# Rezoning Transportation Analysis

Petition Number: 2023-038

**From: Jake Carpenter, PE**  
Jacob.carpenter@charlottenc.gov  
980-221-5675

Date	Description
7-26-23	First Review (IW)

MASTER EXISTING
CONDITIONS PLAN

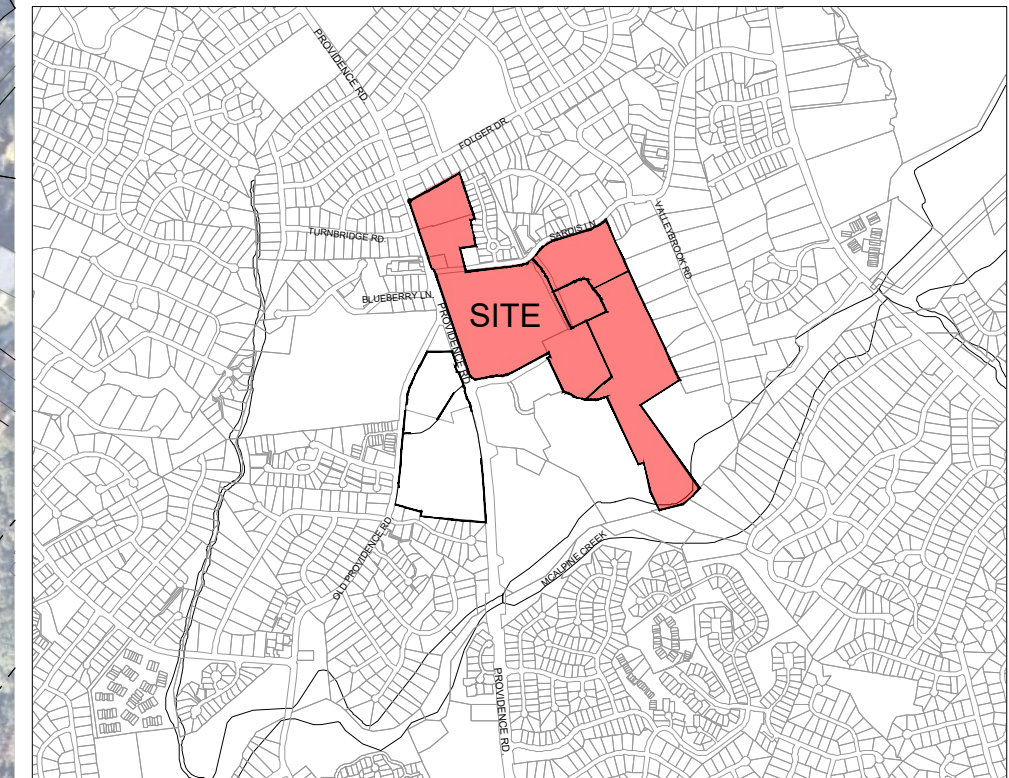
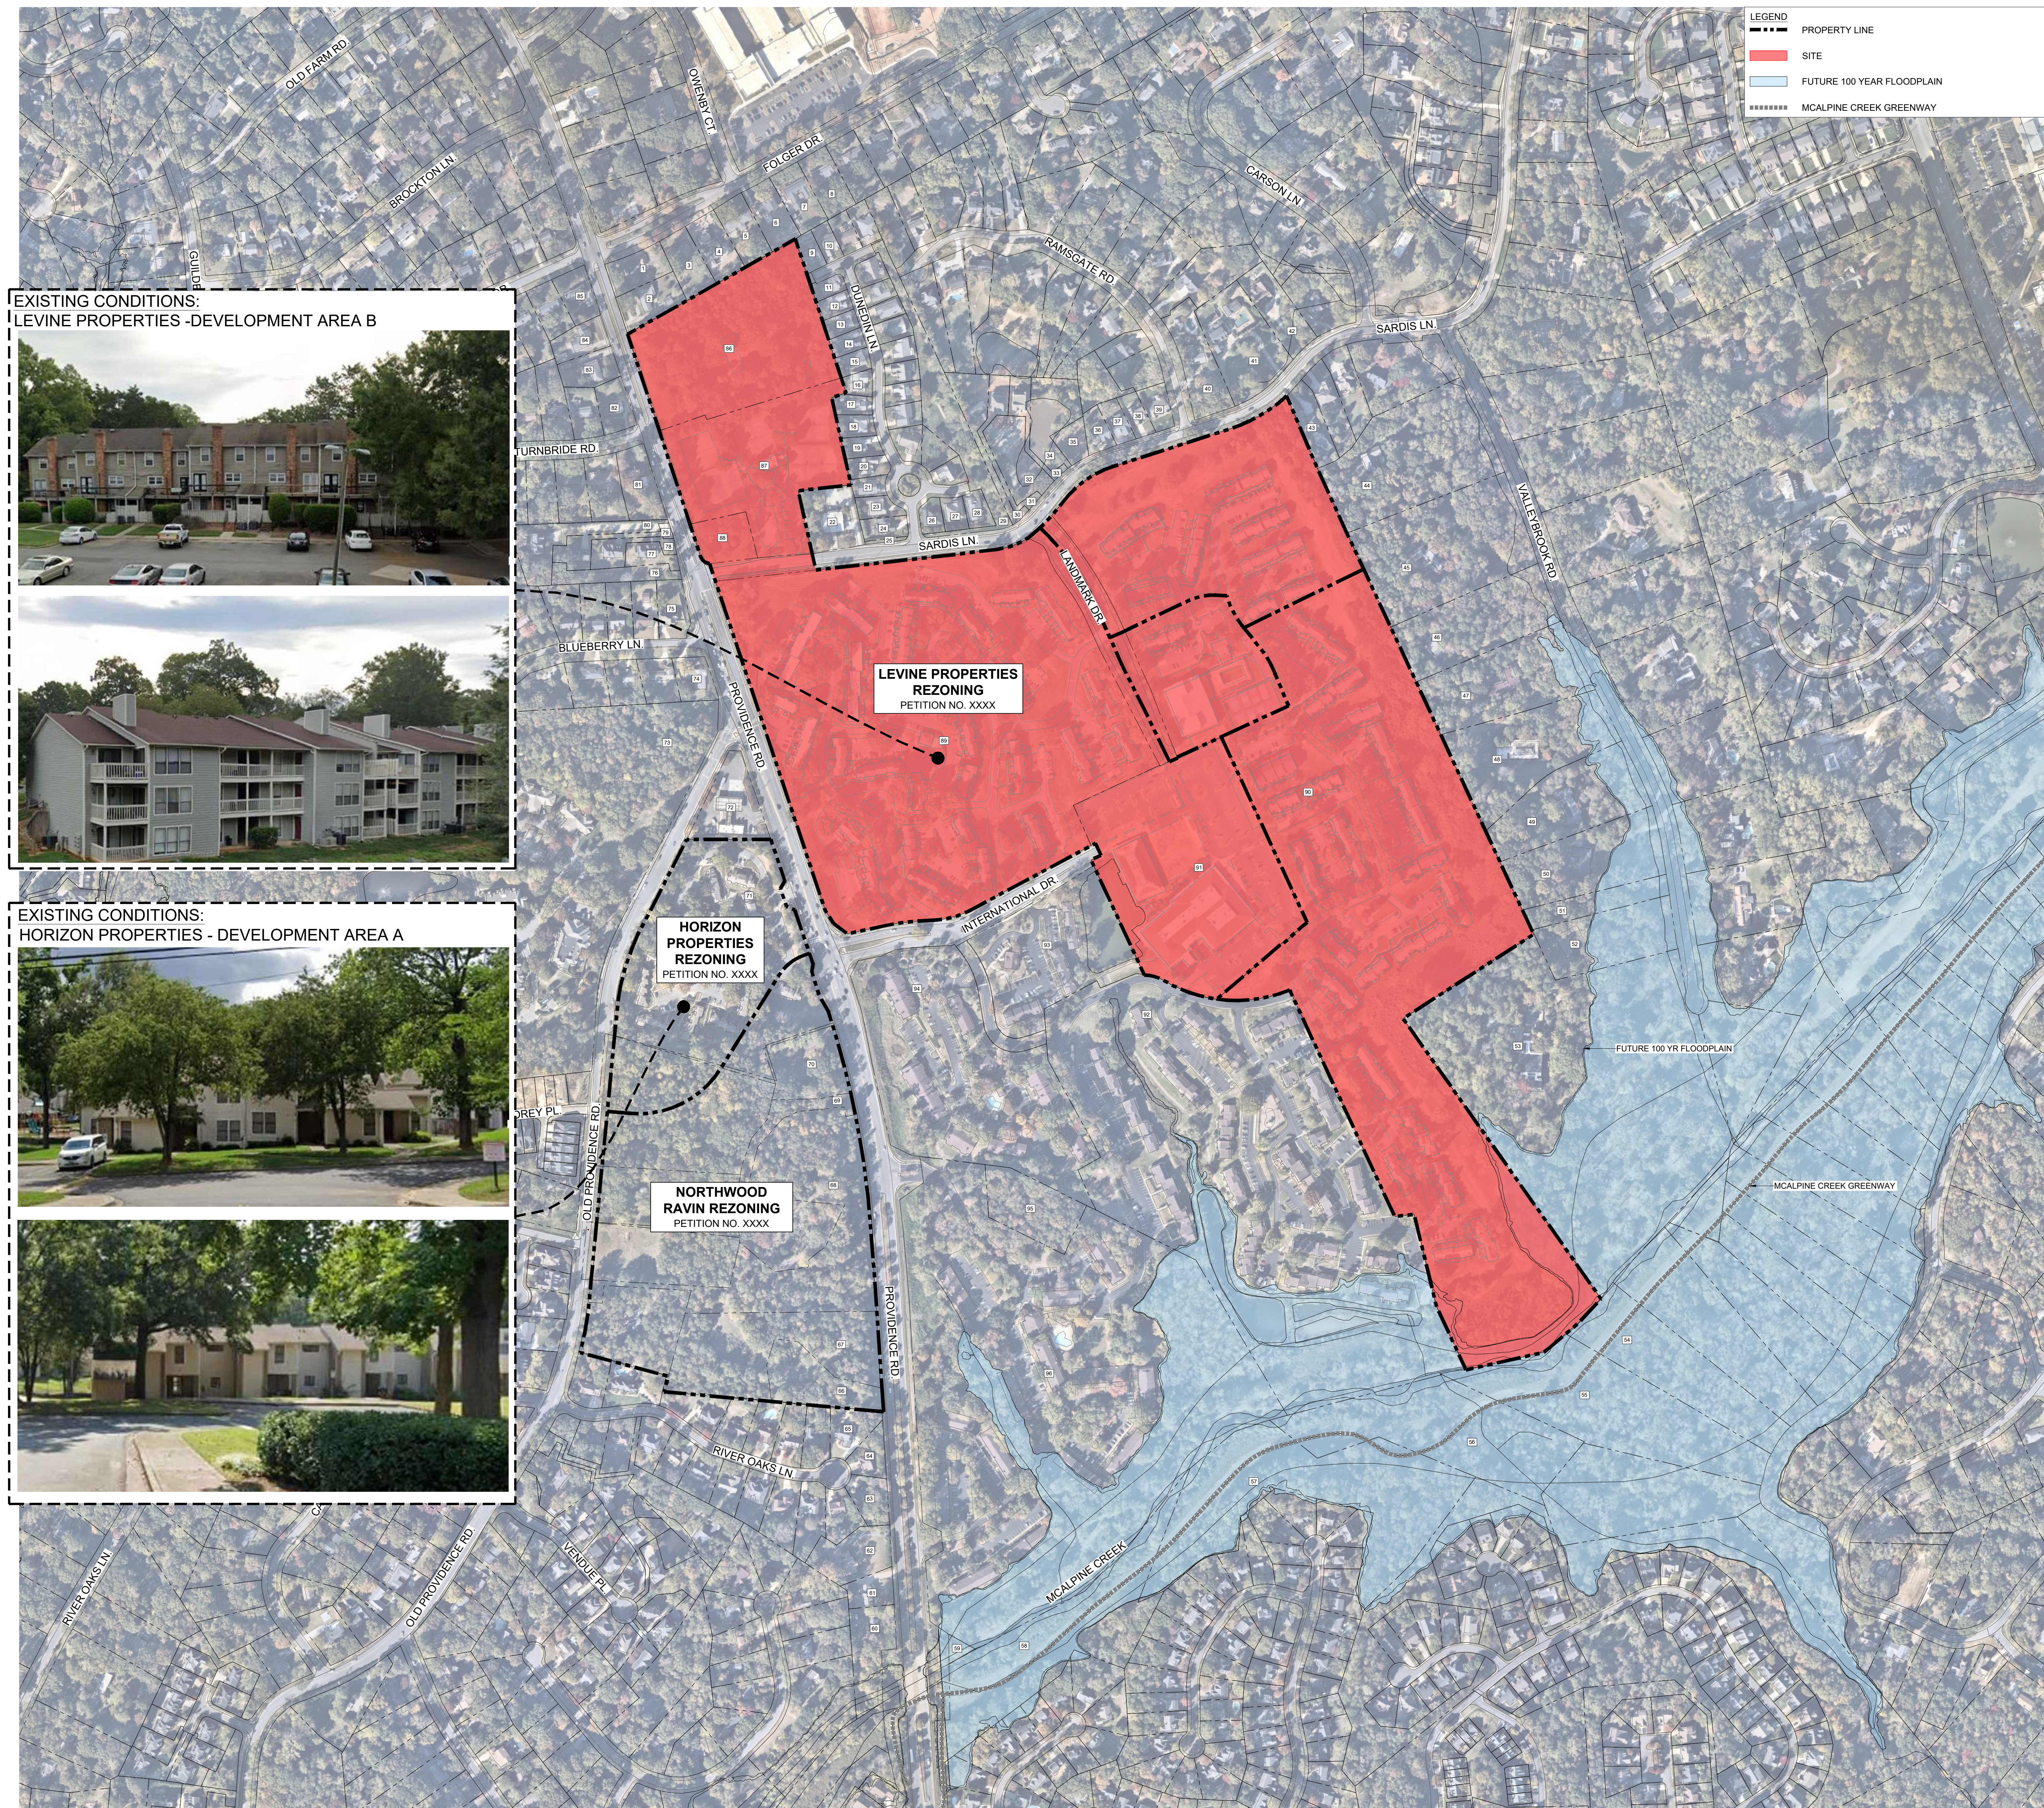
- a. **Providence Road:** Location of back of curb and gutter to be moved to 33 feet from roadway centerline to accommodate the Charlotte Streets Map with a roadway typical section of 4+ Boulevard, shared use path.
  - i. This dimension could change depending on mitigations resulting from the Traffic Study.
- b. **Sardis Lane:** Location of back of curb and gutter to be moved to 24 feet from roadway centerline to accommodate the Charlotte Streets Map with a roadway typical section of 2+ Avenue, Bike lanes
  - i. This dimension could change depending on mitigations resulting from the Traffic Study
- c. **International Drive:** The future location of curb and gutter is in its existing location
  - i. This could change depending on mitigations resulting from the Traffic Study.

NOTE: Additional distance from center line to back of curb may be required in locations where a median is present or around intersections and interchanges.

Label and dimension the curb and gutter from the centerline for each road on the site plan.
